Please ask for: Mrs D Johnson  
Email: [daun.johnson@arun.gov.uk](mailto:daun.johnson@arun.gov.uk)  
Telephone: 01903 737762  
Our Ref: M/30/21/HH  
Your Ref:  
Date: 15th March 2021

**Application for Planning Permission for Works or Extension to a Dwelling**

**Development:** 2nd floor rear extension & additional pitched dormer to front.  
**Location:** 23 The Byway Middleton On Sea PO22 6DR

DRAWING TITLE:
Existing Plans, Elevations,
Site and Location Plans

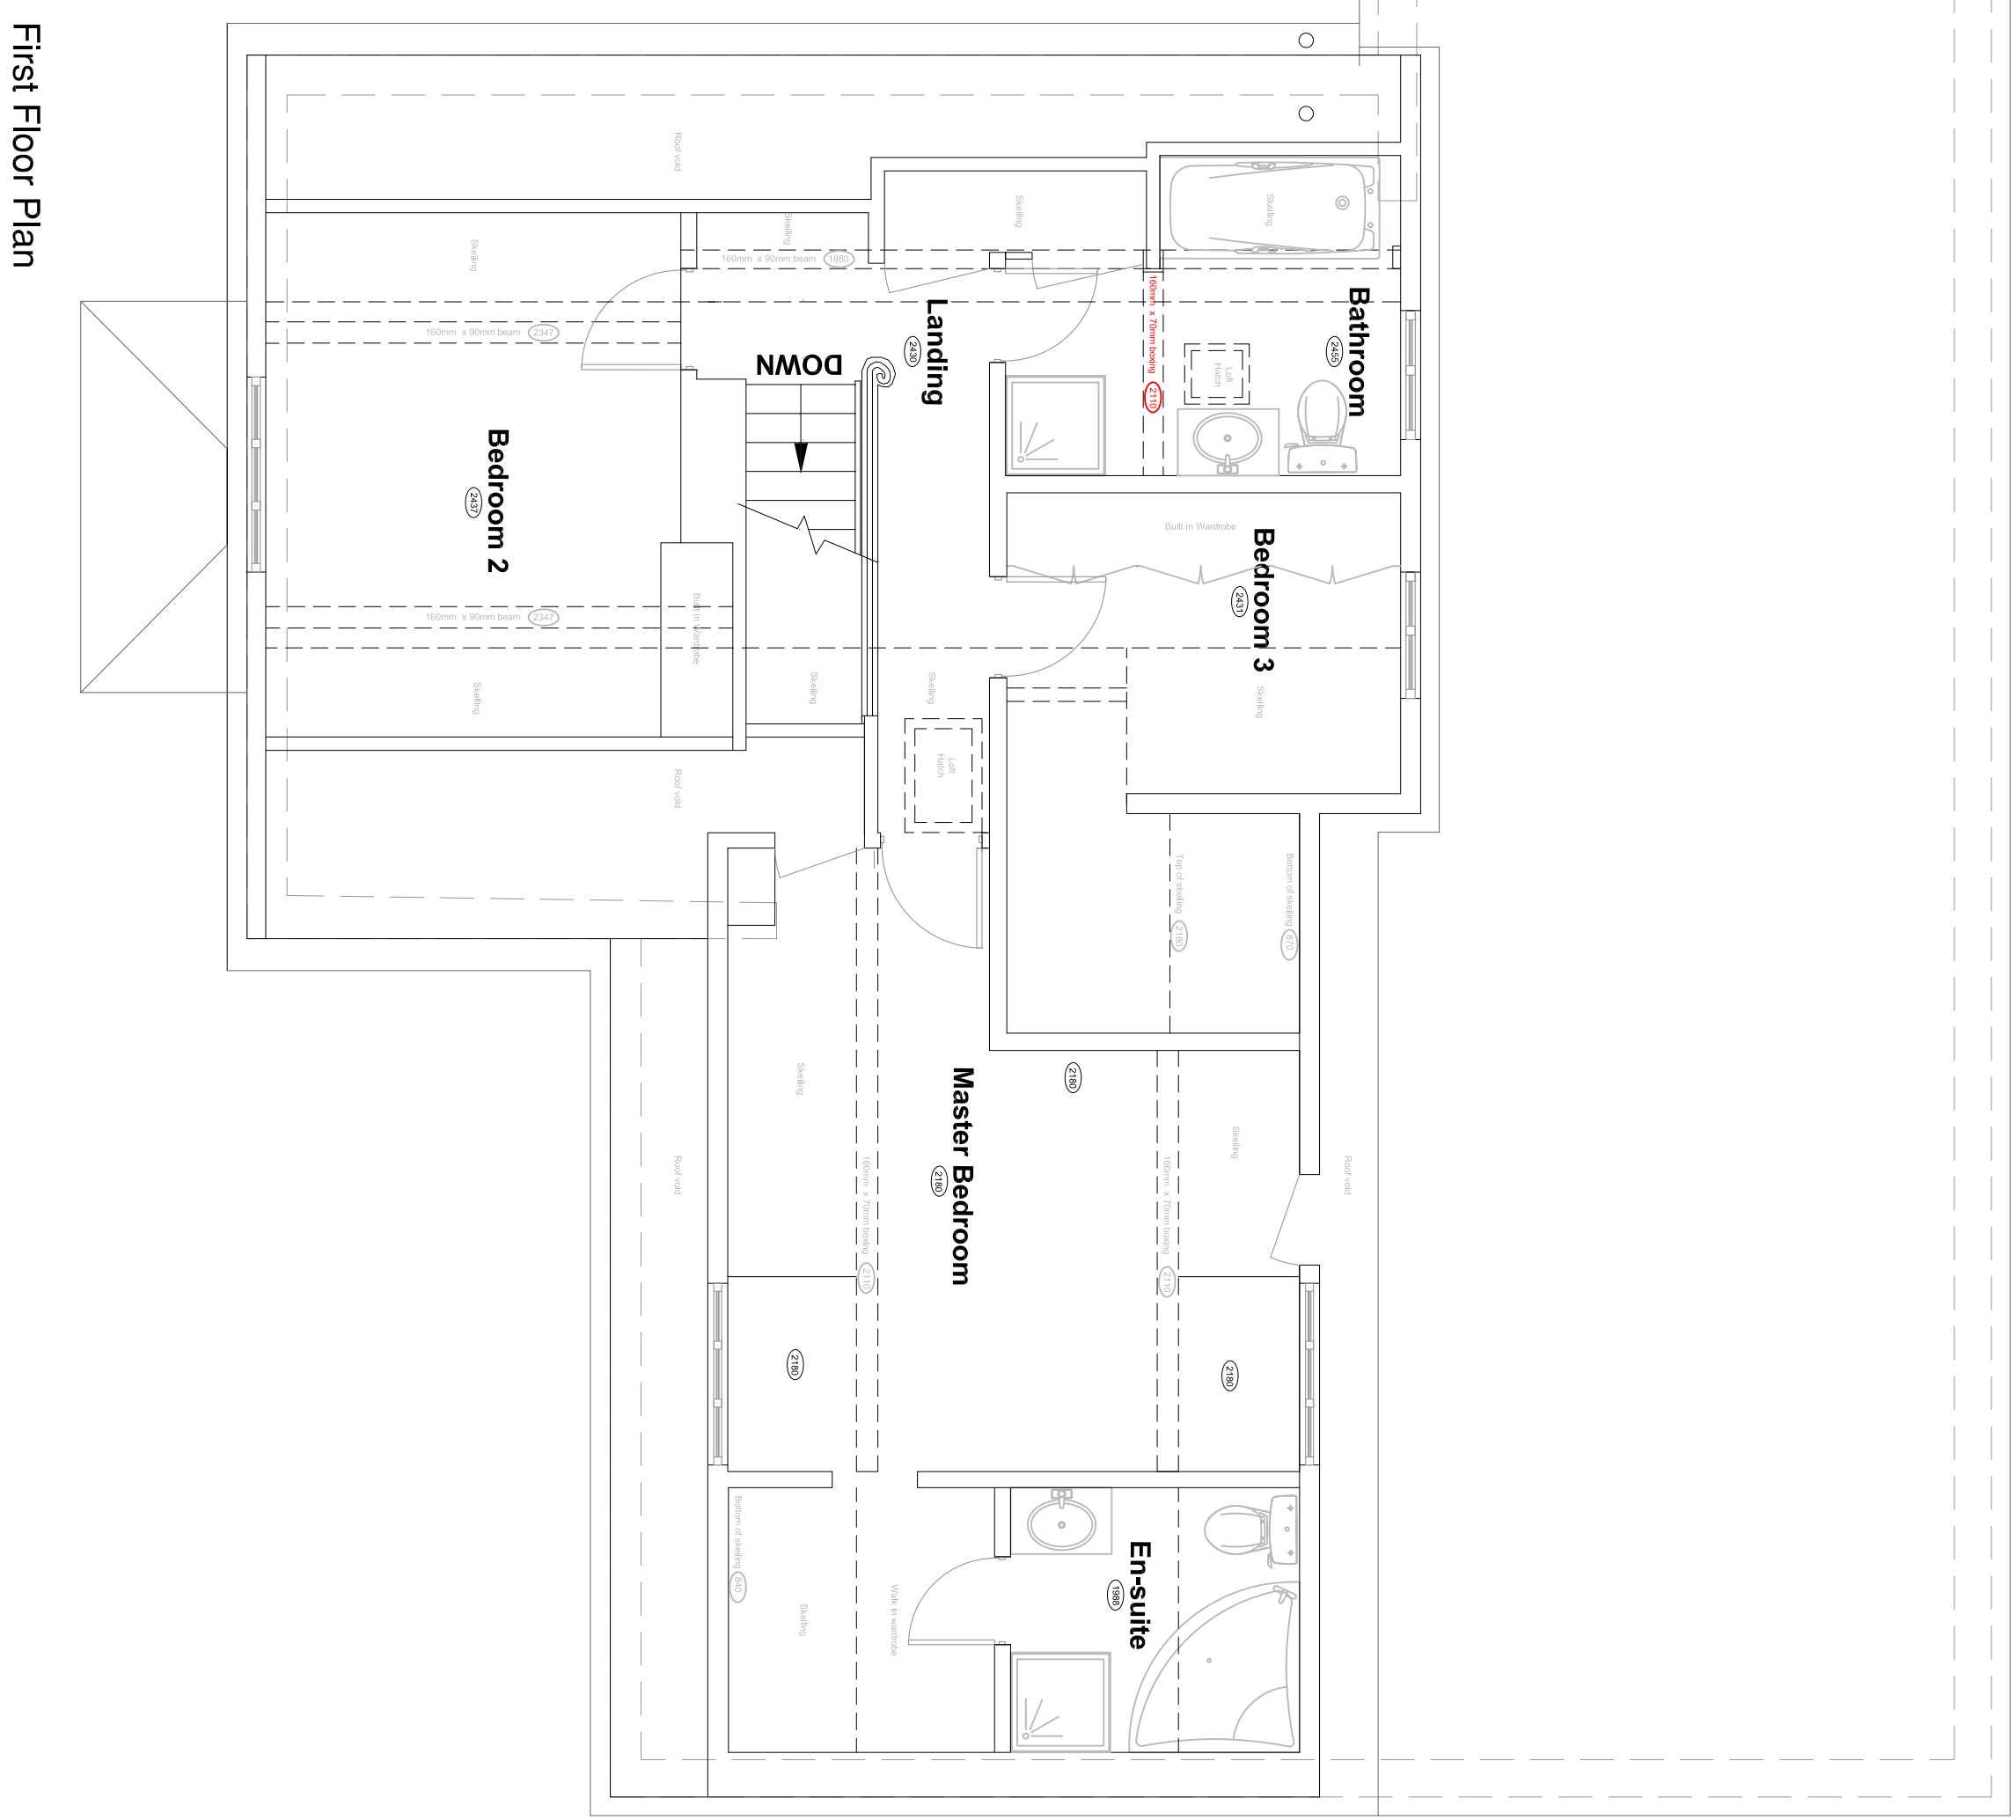
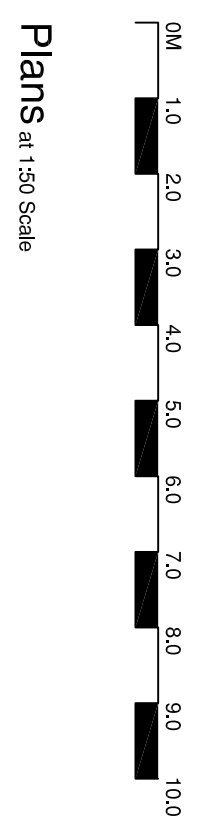
Please provide a north point on the location and block plans.
